OXFORDSHIRE COUNTY COUNCIL'S RESPONSE TO CONSULTATION ON THE FOLLOWING DEVELOPMENT PROPOSAL

Application no: 23/00501/REM

Proposal: Reserved matters application & condition discharge of Part B of 19/00128/HYBRID - Part B: Outline planning application - the development of up to 2 no. commercial buildings having a maximum floorspace of 16,890m² and having a flexible use [to enable changes in accordance with Part 6 Class V of the Town and Country Planning (General Permitted Development) Order 2015 (as amended)] within Class B2 or B8 of the Town and Country Planning (Use Classes) Order 1987 as amended, and ancillary Class B1 offices, with all other matters reserved for future approval (19/00128/HYBRID)

Location: Unit 2, Kalabergo Close, Banbury, OX17 2FJ

Figure 2. Proposed Site Plan

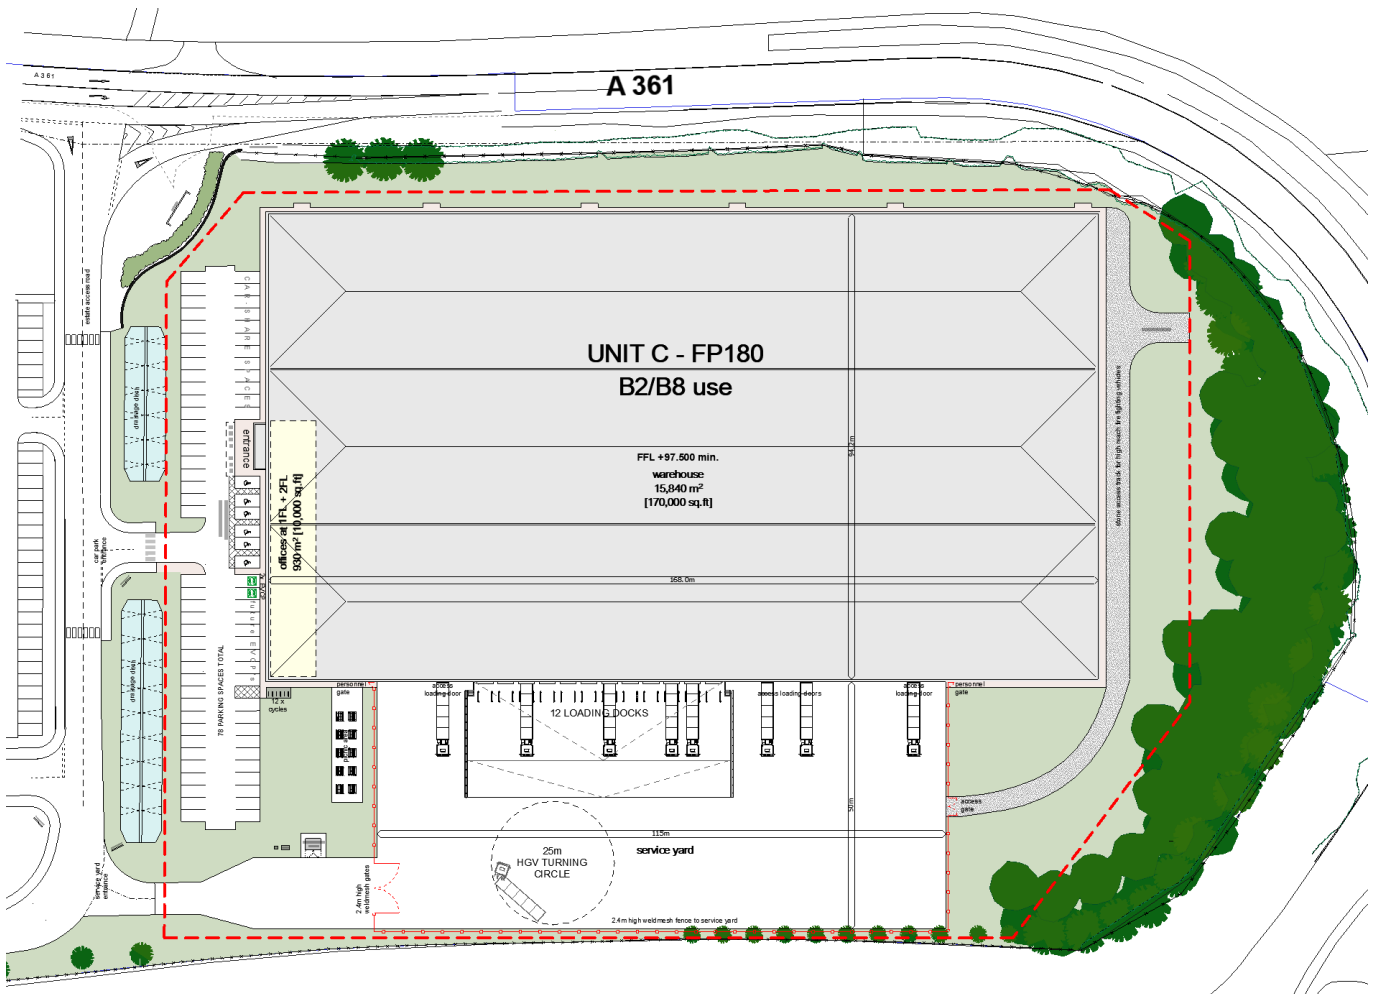
The application proposes a total of 78 spaces, i.e only 67% of the appropriate provision.

The under-provision is a reason for objection unless it can be satisfactorily justified. Any overspill parking will be on the estate access road and will cause an obstruction to the

All spaces must be a minimum of 5.0m x 2.5m, with a minimum 6.0m wide corridor for manoeuvring. It is recommended that a turning area be provided at each end to save vehicles from having to turn around in the corridor if all spaces are occupied.

The operation of the twelve “car-share spaces” needs to be explained so that the impact on overall parking provision may be assessed.

The Site Plan identifies only two spaces with EV charging facilities and seven spaces for future installation. This is well below the requirements and is a reason for objection.

The proposed number of spaces (12) is considerably lower than the required provision and has not been justified, so is a reason for objection.
